Comments on the Applicant's D3 Submissions

This document sets out the comments by Cambridgeshire County Council (**CCC**) on the Applicant's Deadline 3 (**D3**) submissions. The table below provides the relevant paragraph or reference numbers.

2.6 Statutory and Non-Statutory Sites or Features for Nature Conservation Plan P03 [\[REP-3-008\]](#)

Dwg no
3149-2.6-000

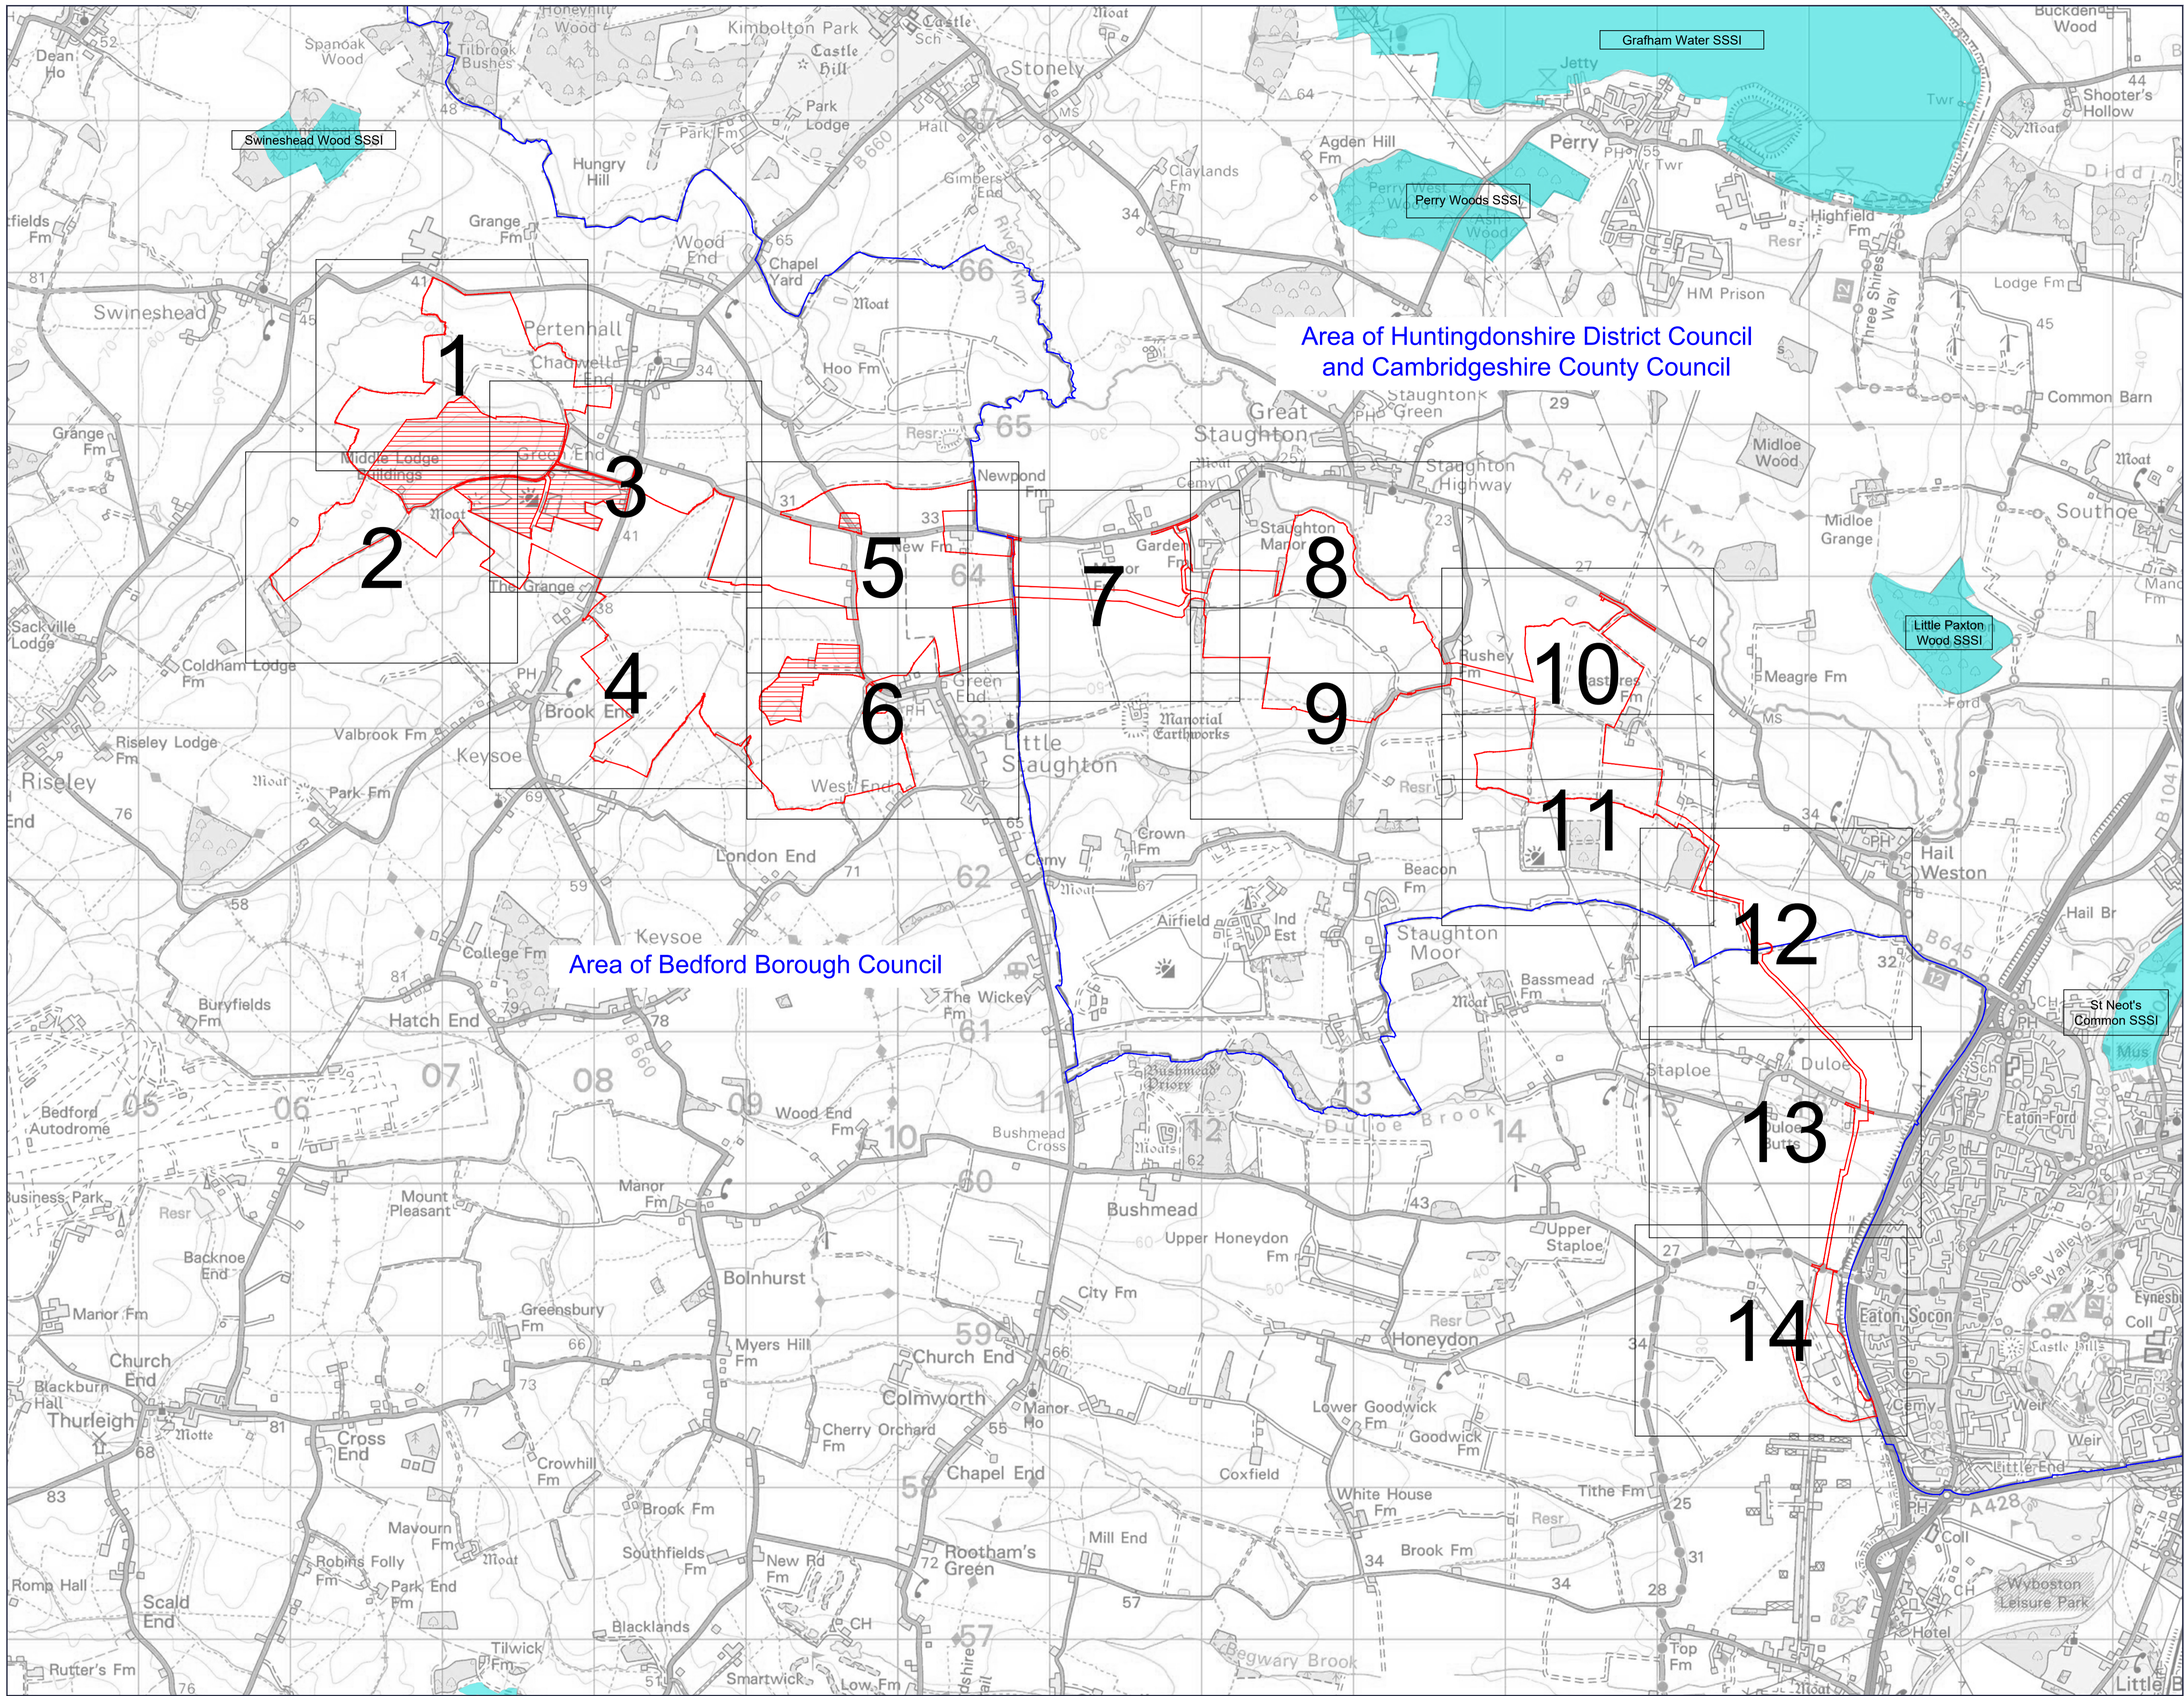
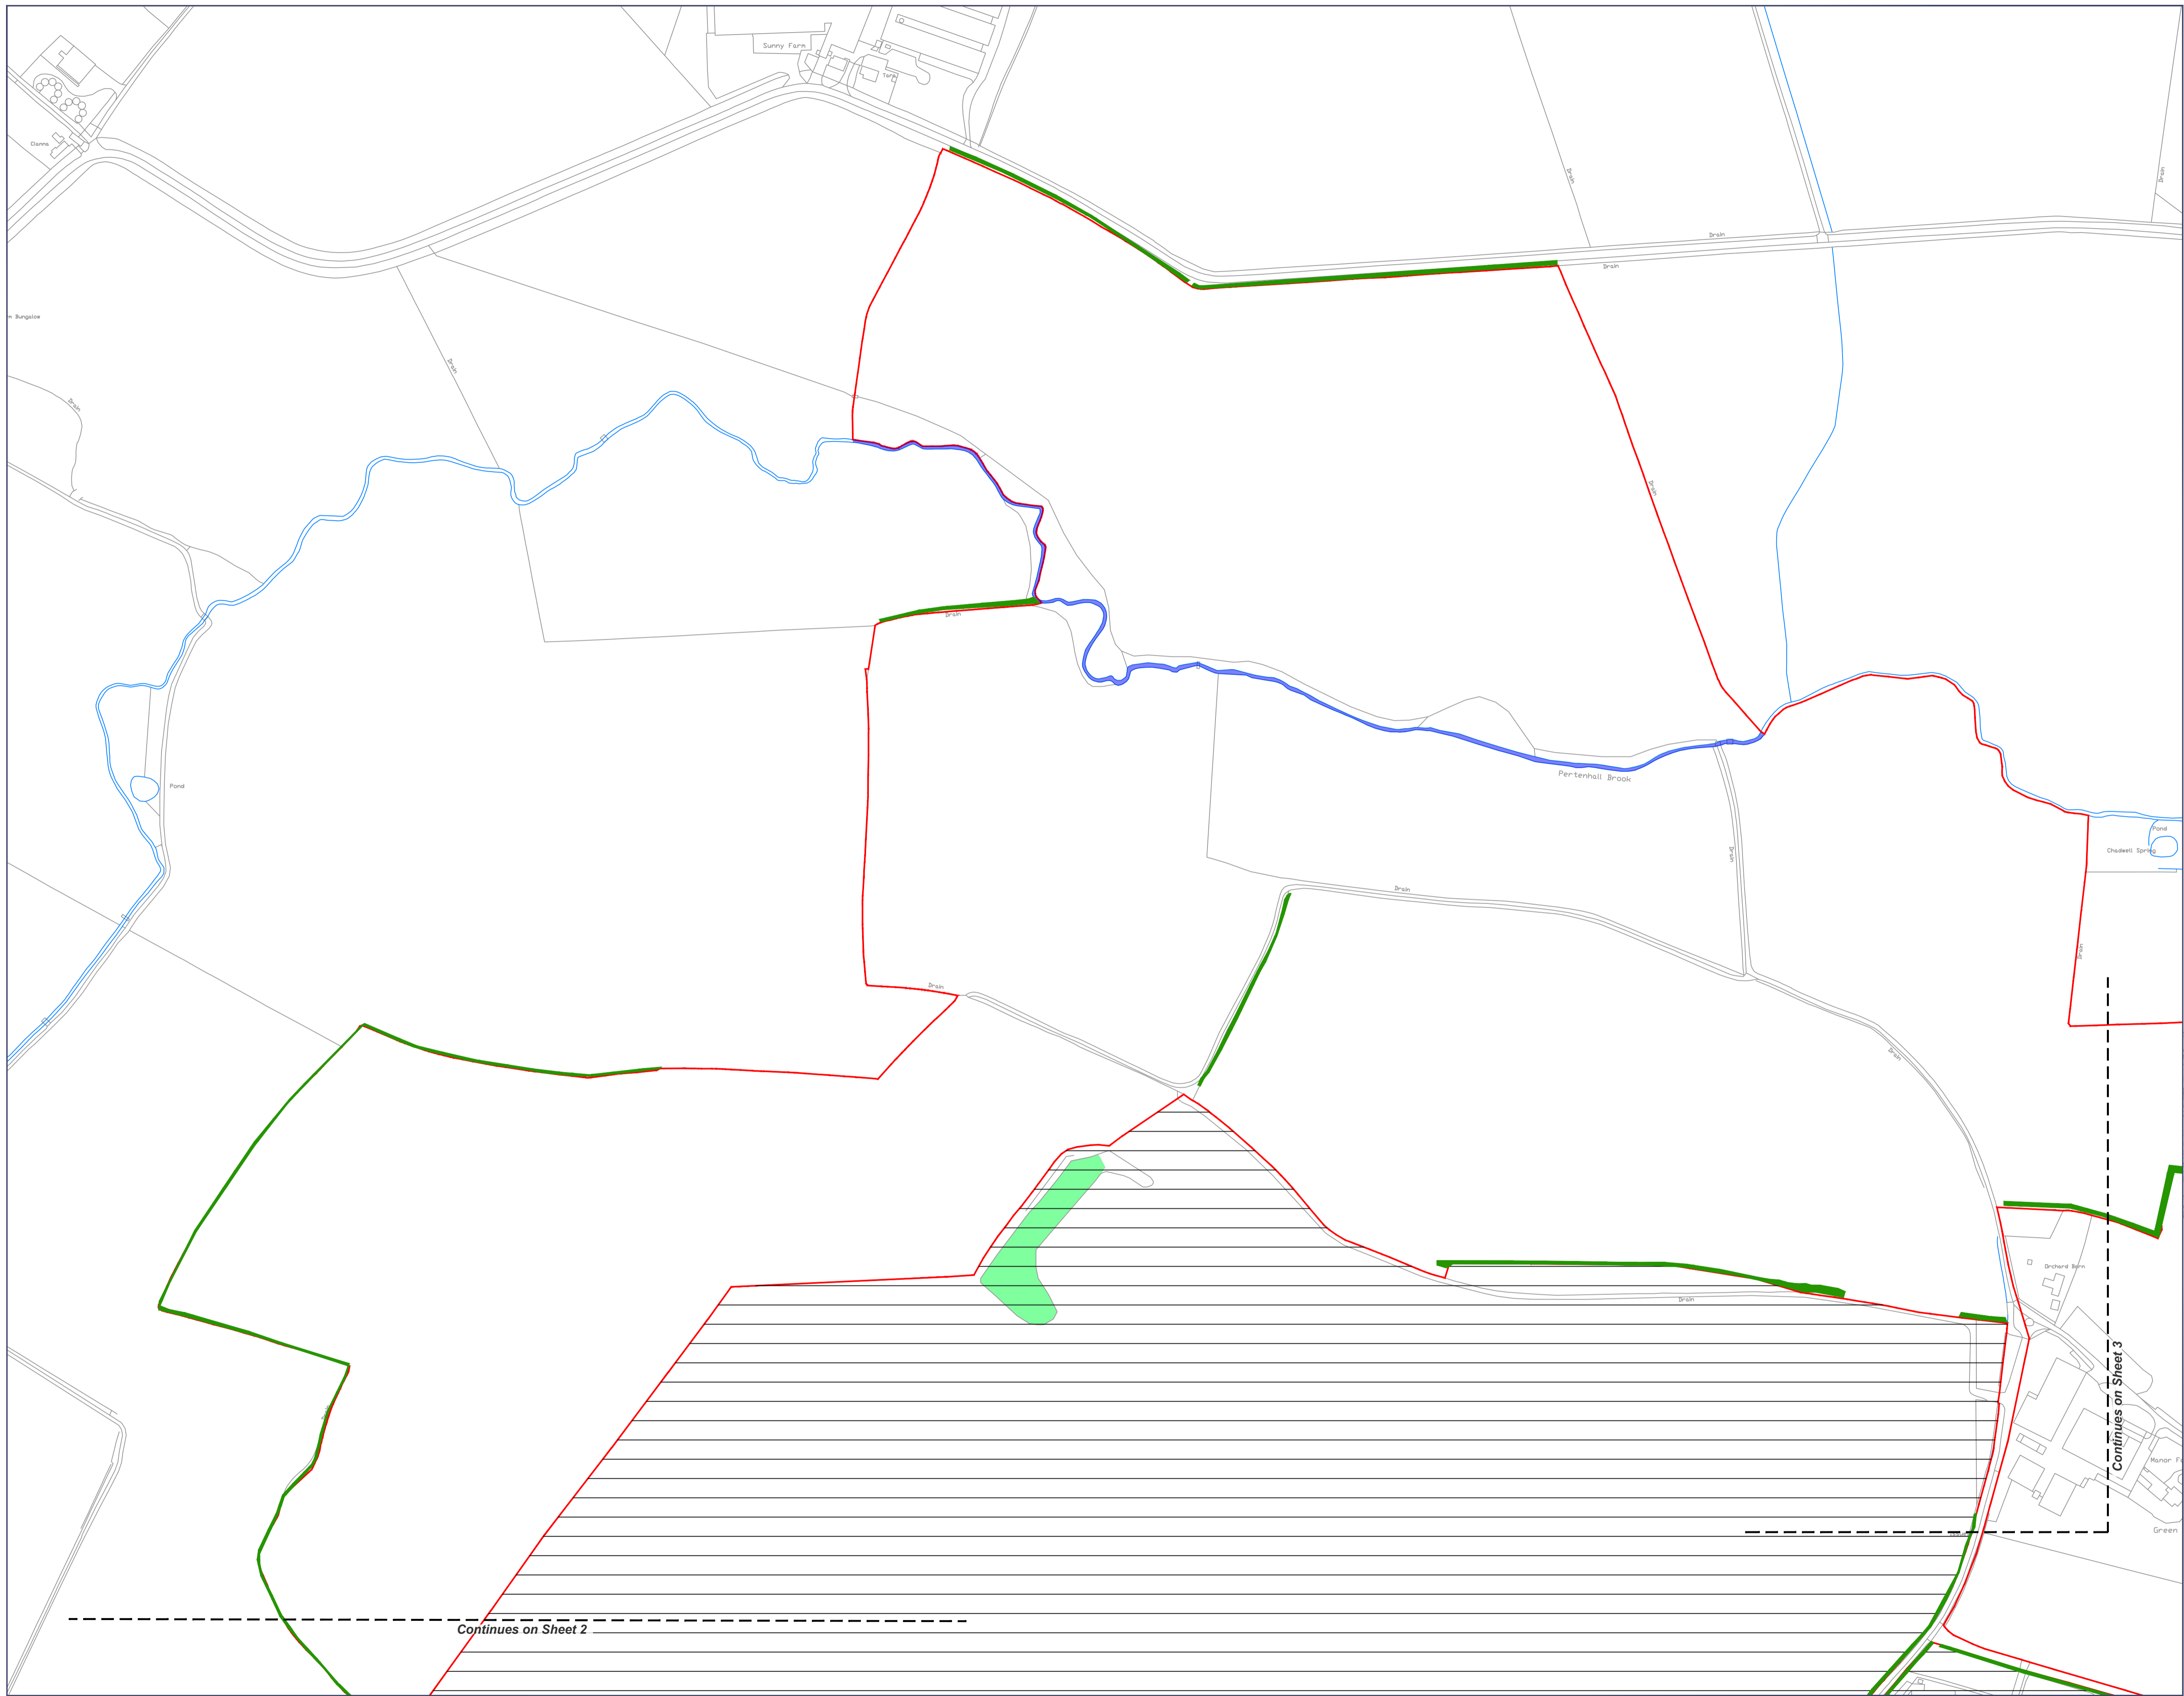
Topic	Paragraph Number	Council's Comments
Irreplaceable habitat	-	For completeness, the council recommend that the drawings are updated to show all irreplaceable habitat that have been recorded within the order limit, or that could be impacted by the scheme. For example, veteran/ancient trees (identified in the tree surveys and considered in the biodiversity net gain calculations).
